Consultation Response from KC, Highways Development Management
2026/91516 200, Raikes Lane, East Bierley, BD4 6RD
Removal of car port, relocation and alterations to existing detached garage, erection of single storey rear extension, side porch and conversion of existing hipped roof to gable and erection of rear dormer
Date Responded: 25 June 2026 Responding Officer: Sheila Henley Responding Ref: 8-8SW/6

Plan ref: SK261094/P02 rev A - Proposed Site and Floor Plans A1

Revision	Description
Location	
PLANNING	
B Clark 200 Raikes Lane East Bierley Bradford BD4 6RD	
Title	
Proposed Site and Floor Plans	
Scale	Drawing No.
As indicated @A1	SK261094 / P02
Revision	Revision
A	A
hello@spokelimited.co.uk	
tel: 0113 335 0975

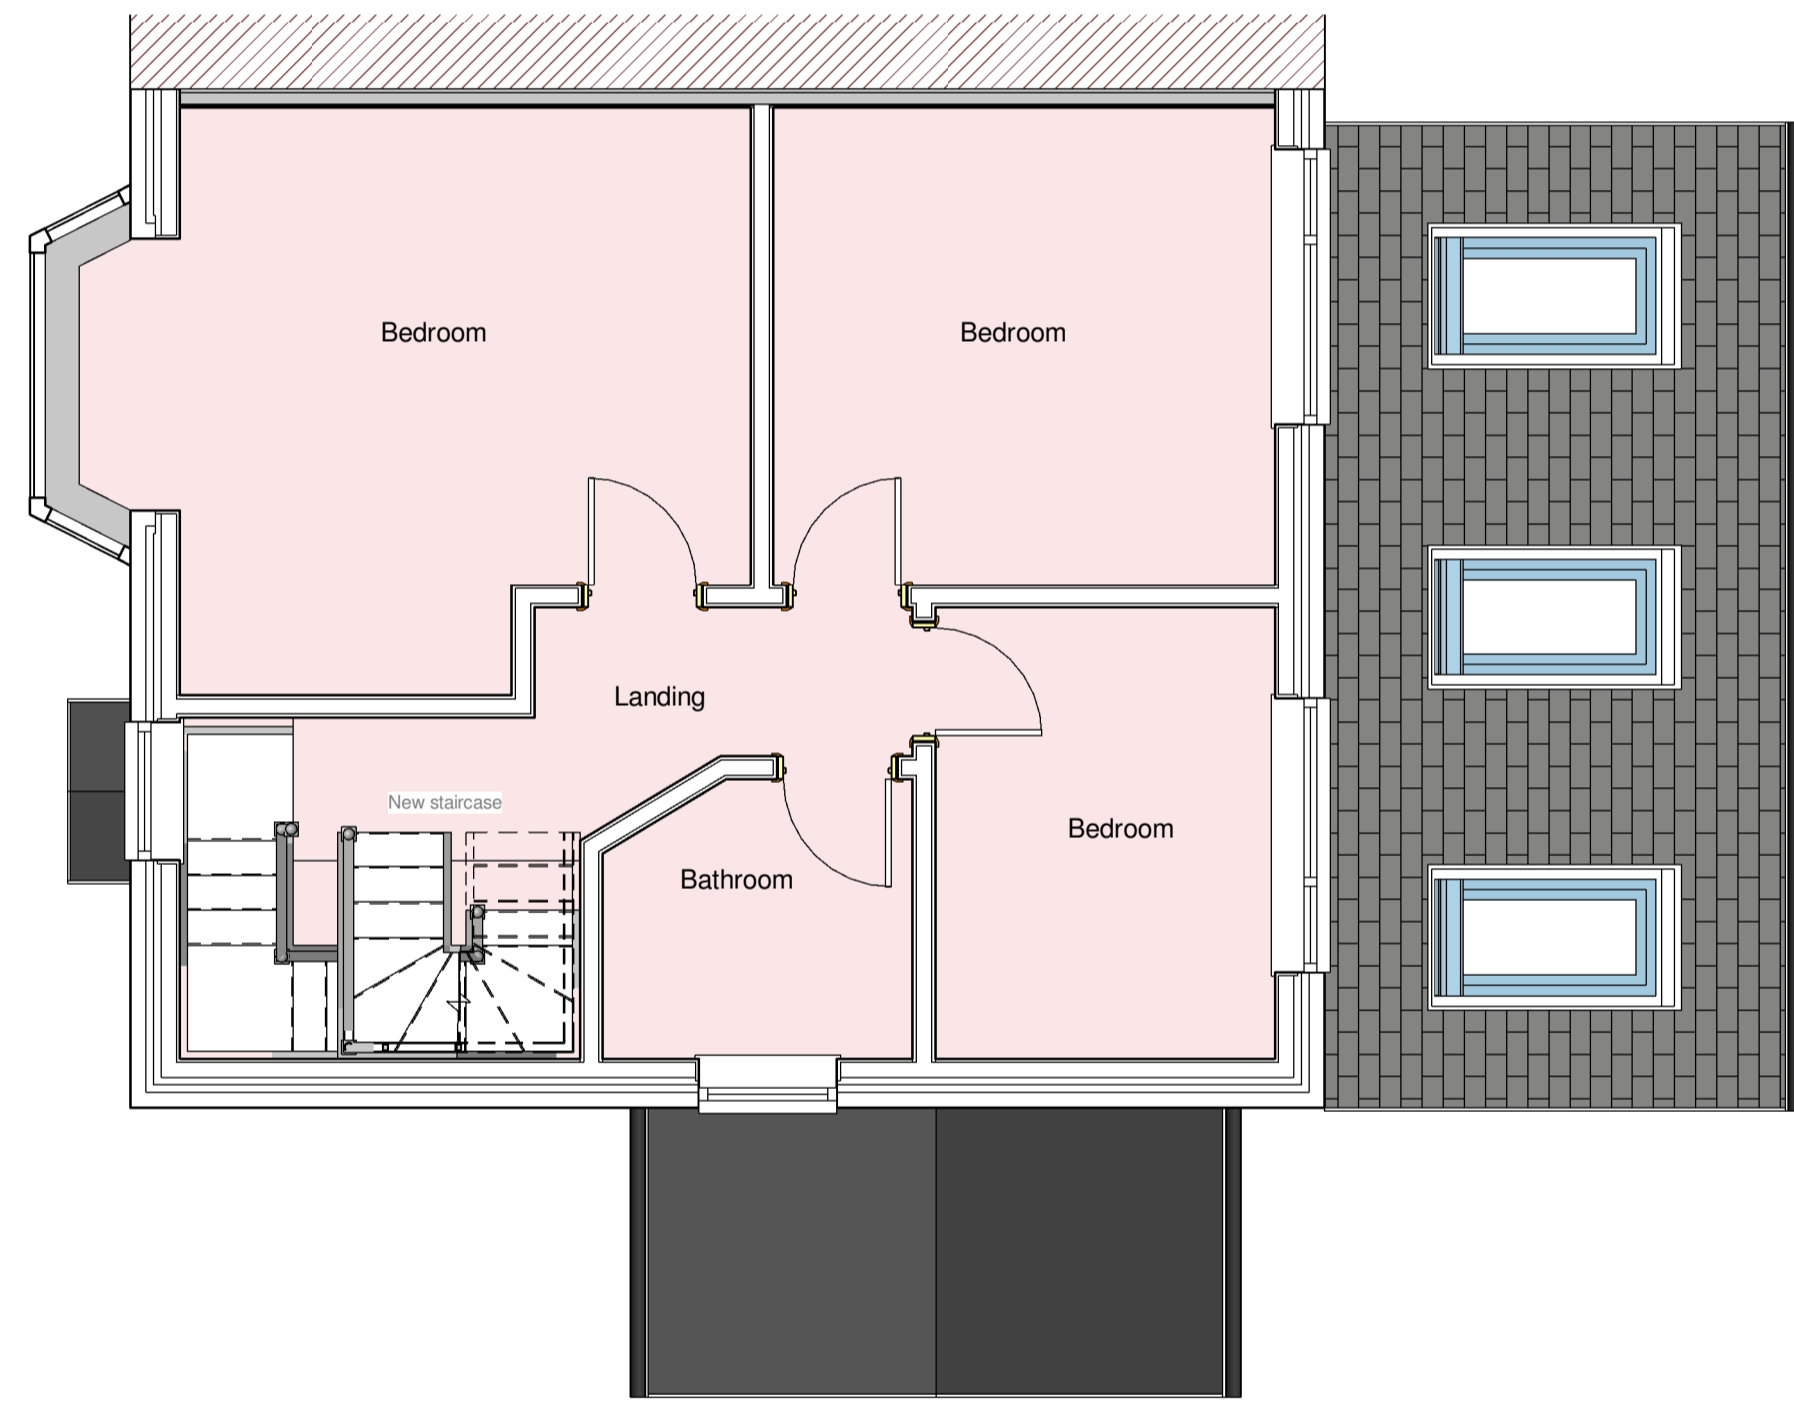
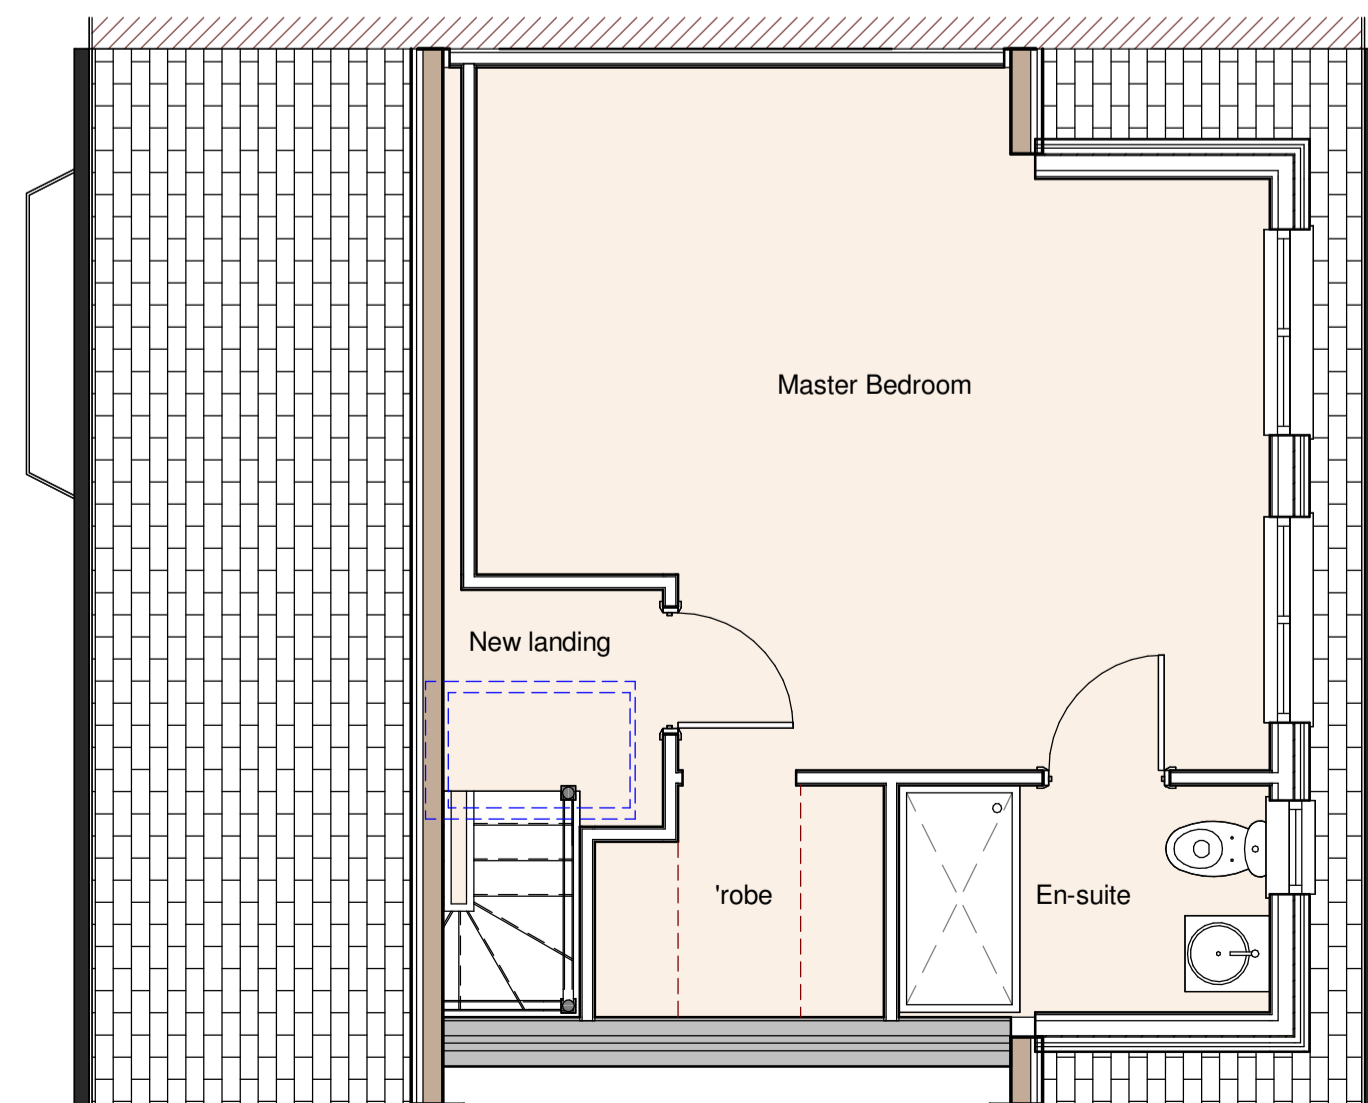
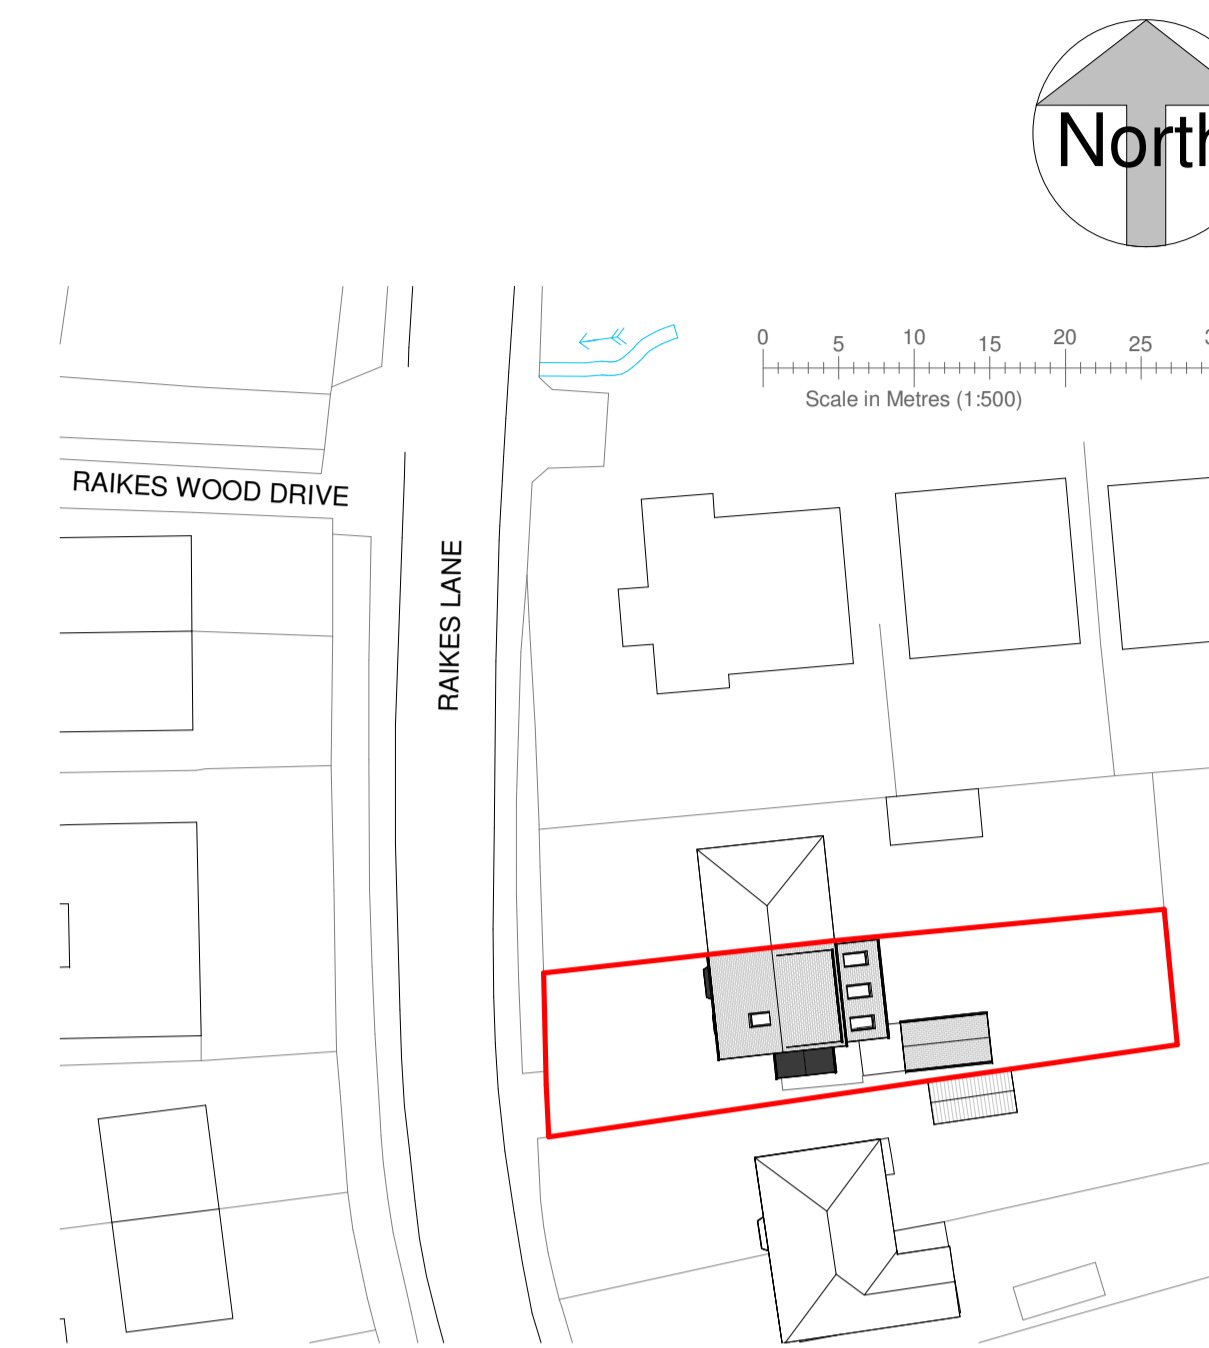
The proposed extension to include an additional bedroom from the existing three bedrooms, removal of a car port, and alterations to the detached garage is acceptable in highway terms.

The existing access, bin storage space, and sufficient exterior on-plot parking would be retained. Three car parking spaces typify four bedroomed + units as advised by the Kirklees Highway Design Guide SPD and meet policy LP22.

Space for other storage is indicated within the modified garage to continue any provision for cycle parking.

To further support sustainable travel and lower emissions, plus policies LP20 and LP24, the Applicant should consider installing an electric vehicle charging point.
